From: Sue Howell
Sent: 08 May 2017 15:42
To: Planning.Responses
Cc: David Innes
Subject: RE: Planning Consultation on A/47/17/DOC

Application A/47/17/DOC is seeking discharge of Condition 18. Condition 18 of application A/144/15/PL requires the laying out of details, timetable for provision, future maintenance of public Open Space. Boundaries to be defined, their proposed use, the items of equipment and means of enclosure.

APPLICATION NO: **A/47/17/DOC**

Description of Works: Application for approval of matters reserved by condition imposed under A/144/15/PL relating to condition 18 for details of Public Open Spaces.

Date 05.08.16 Drawing No. DHA/728/011 Rev. -

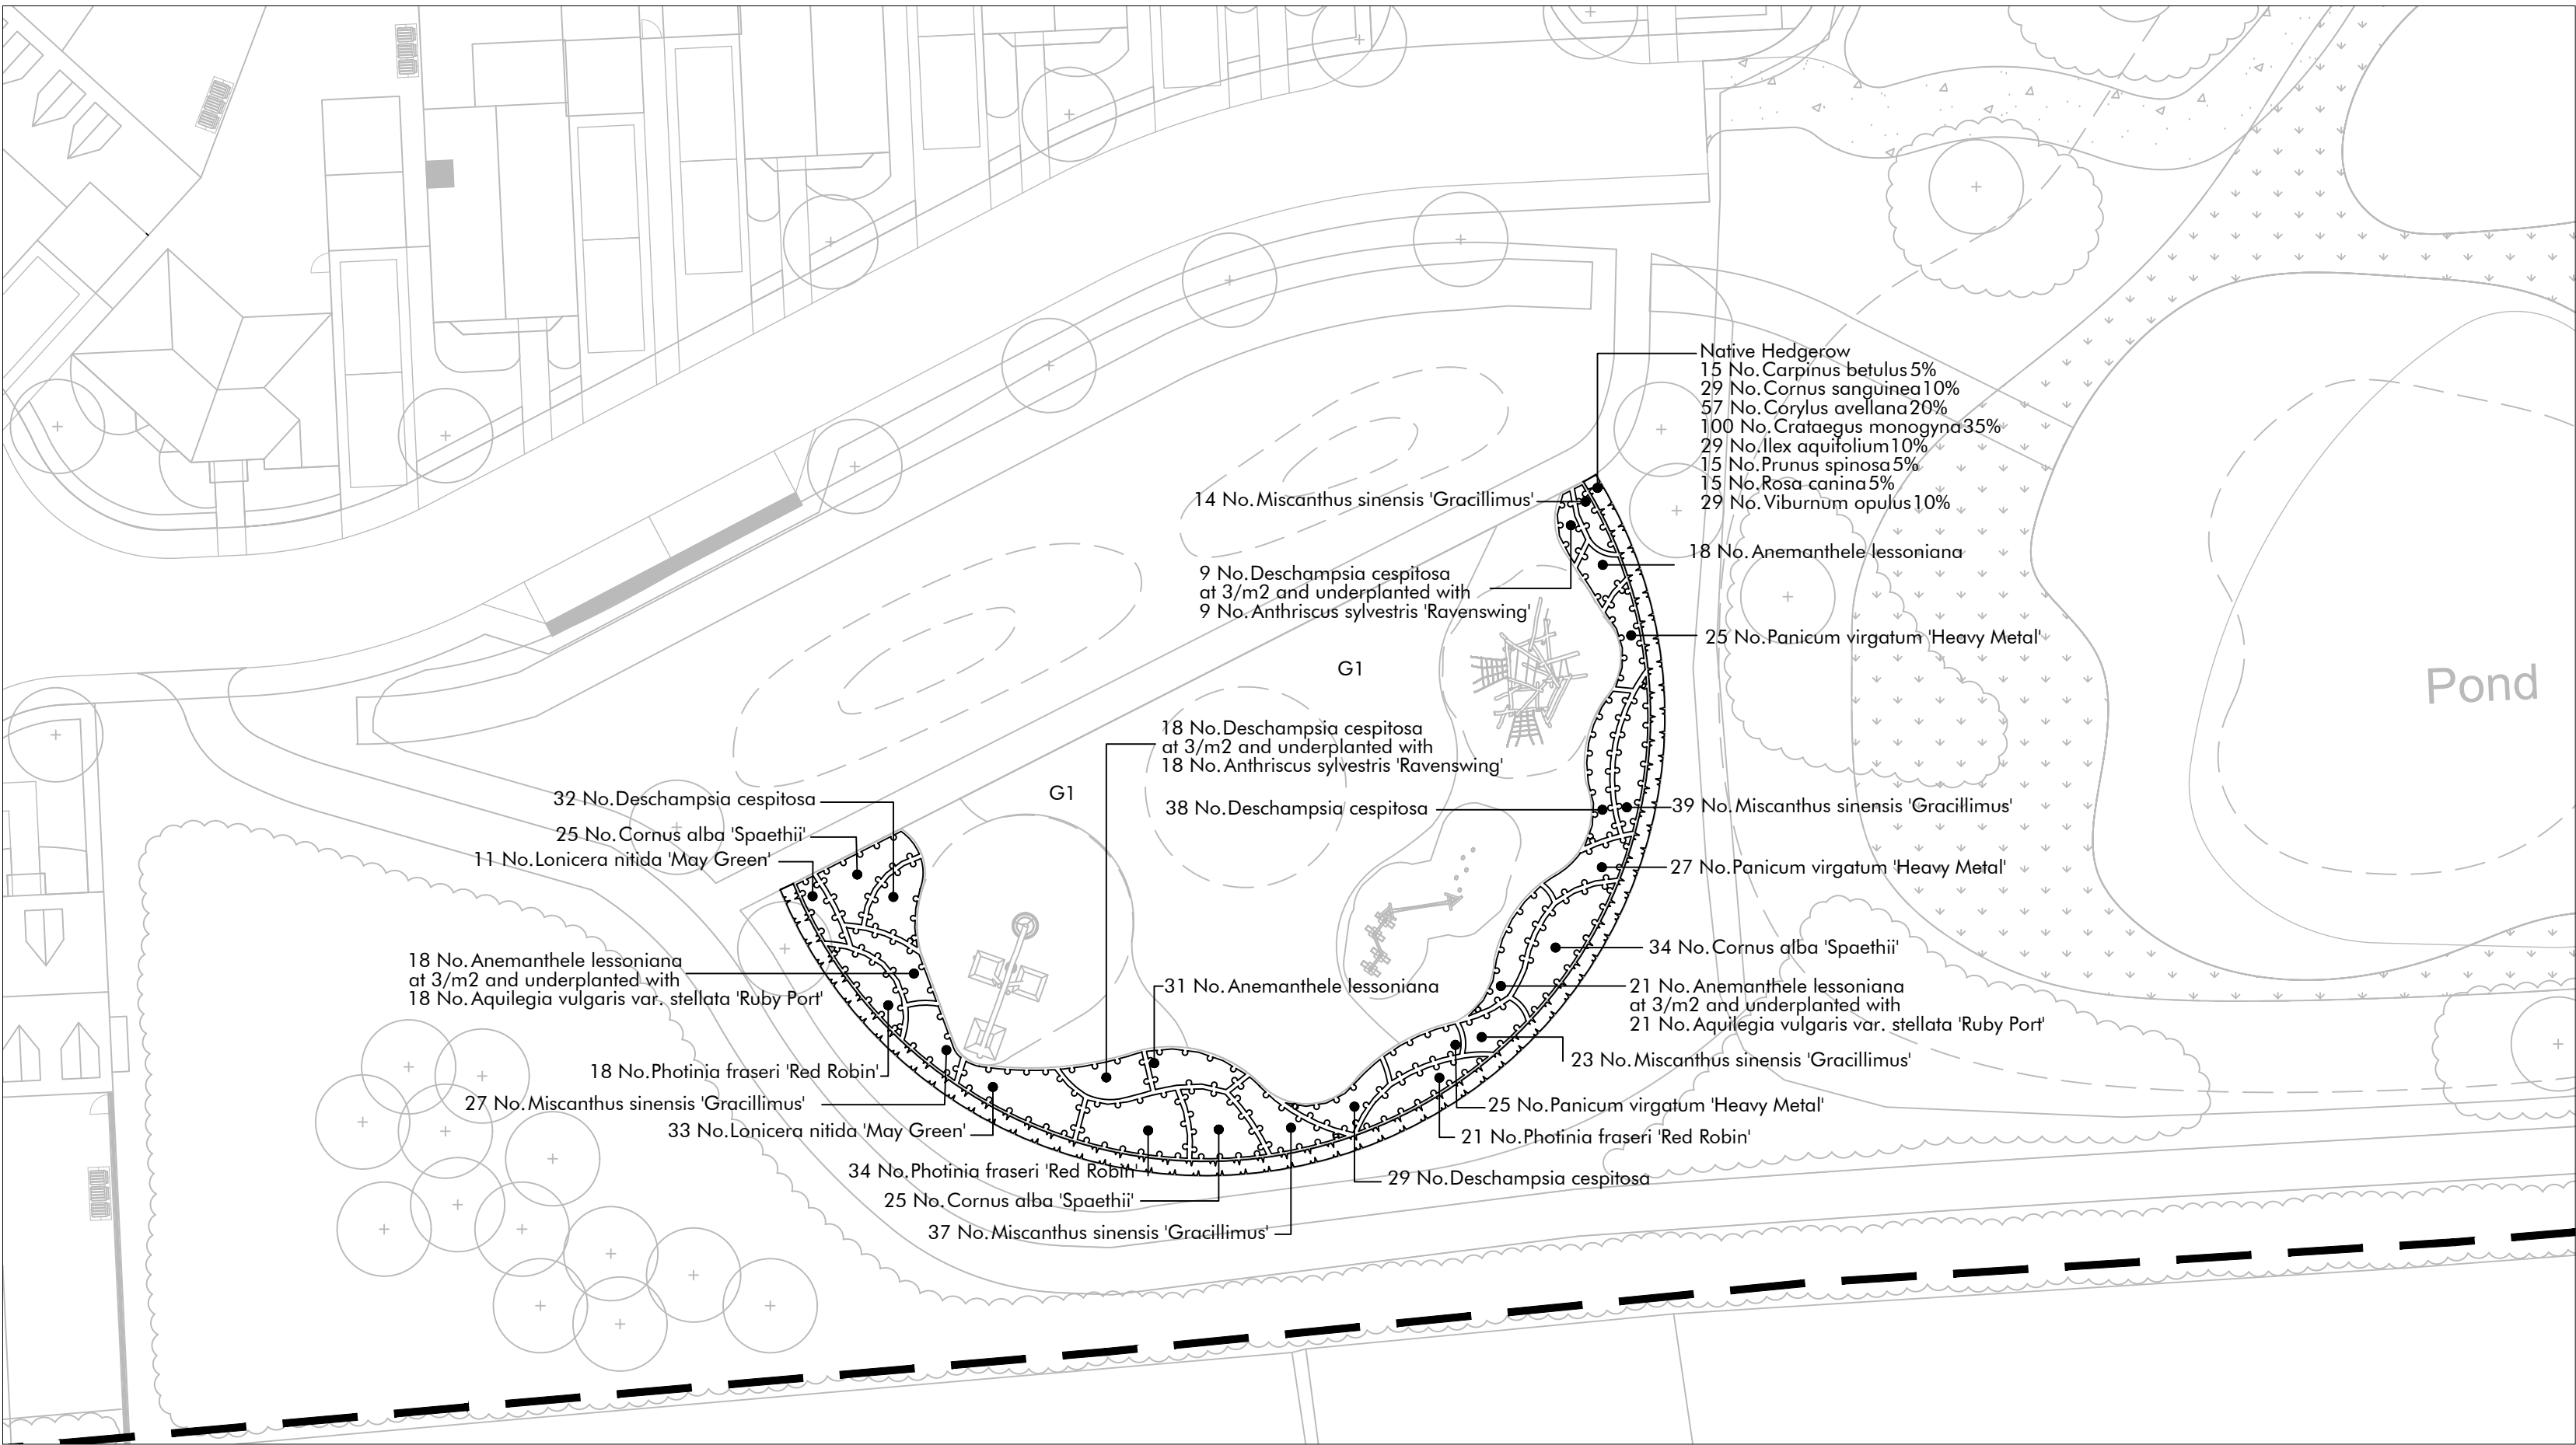
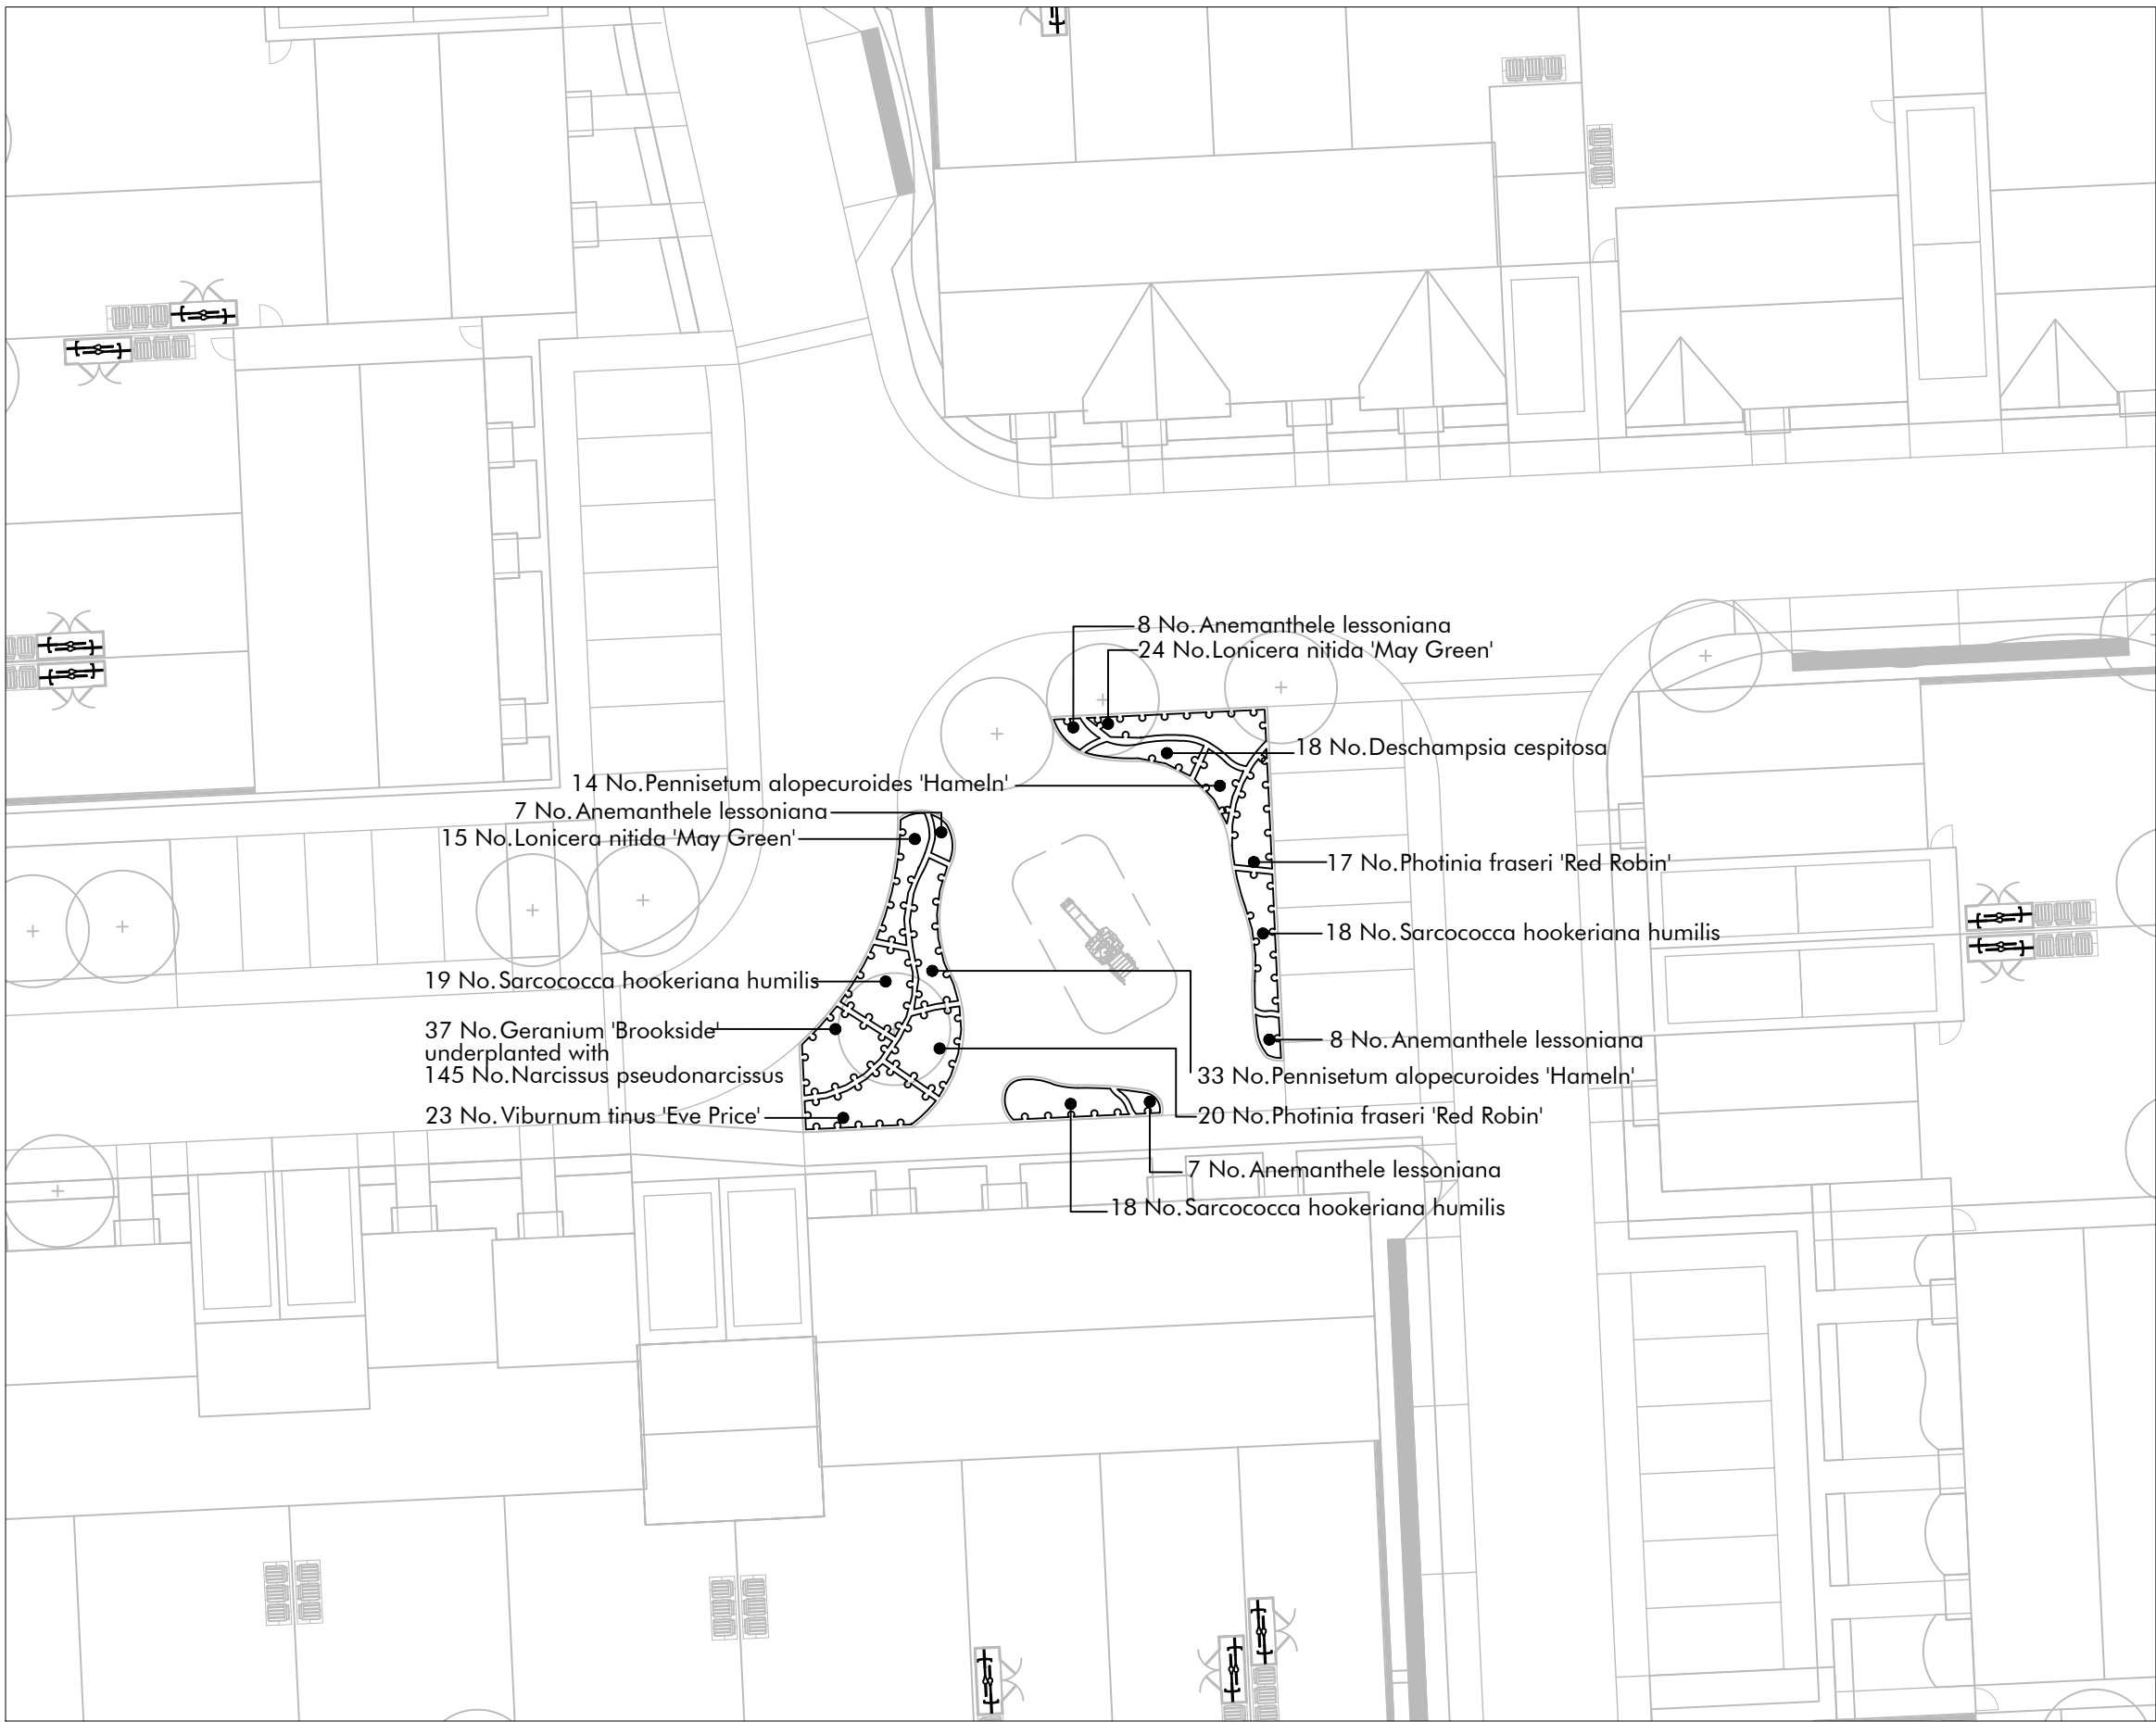
The information submitted within Phase two planting plan, Dwg 15035 P163, DHA/728/008 & DHA/728/011 provides adequate detail of the proposals which we would advise are suitable for location having considered age range provision and experiences being provided. The landscaping scheme proposed is good and will provide enhancement to the built up area, improving the habitat potential and biodiversity within the site. The laps being provided we note are shown as equipped, these can be as effective by just providing small areas of open space specifically designated and primarily laid out for very young children to play close to where they live. The splitting of the NEAP whilst not ideal, does cater for the requirements and would not be detrimental to the effectiveness of this provision. The choice of equipment has been well thought out and the play offer good. Cala Homes have confirmed that the open space and play areas will be retained under Management Company and will not be transferring to the Local Authority. We would note as an advisory that a ROSPA inspection is carried out to the play areas in relation to the waterbodies within the site.
